From: Simon Davis <Simon.Davis@arun.gov.uk>
Sent: 12 December 2019 17:51
To: Planning.Responses <Planning.Responses@arun.gov.uk>
Subject: FW: Y/101/19/DOC - Yapton View (land off Burndell Road), Yapton, BN18 0HW

In relation to the above application, I understand from the submitted documents that Geo-Environmental's Remediation Strategy and Verification Report (ref.: GE18533/RSVR/SEP19, dated September 2019) has been provided with the aim of allowing discharge of condition 3 (remediation strategy) and condition 5 (verification plan). In order for this Department to consider discharging the conditions, please may the following points be addressed:

Site Photographs

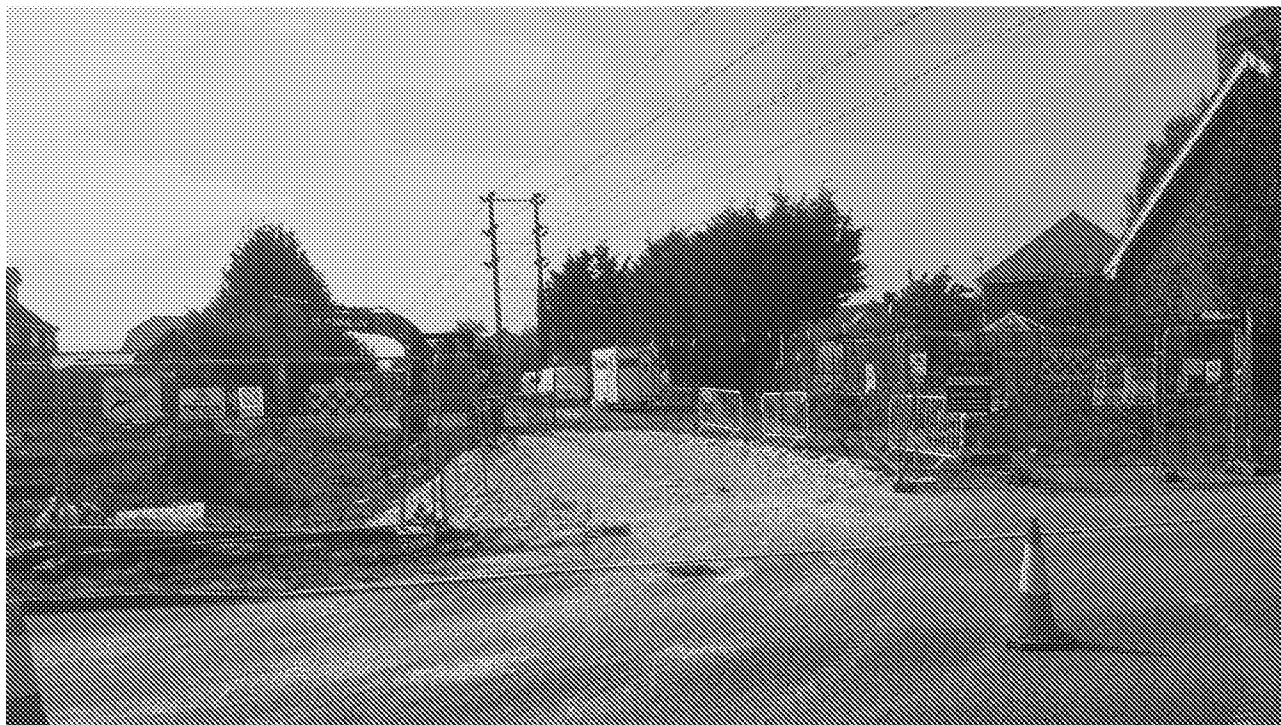
The three pictures in Appendix A do not appear to show the membrane or evidence imported material; please may photographs demonstrating the membrane installation at depth and copies of the transfer tickets for the imported material be provided.
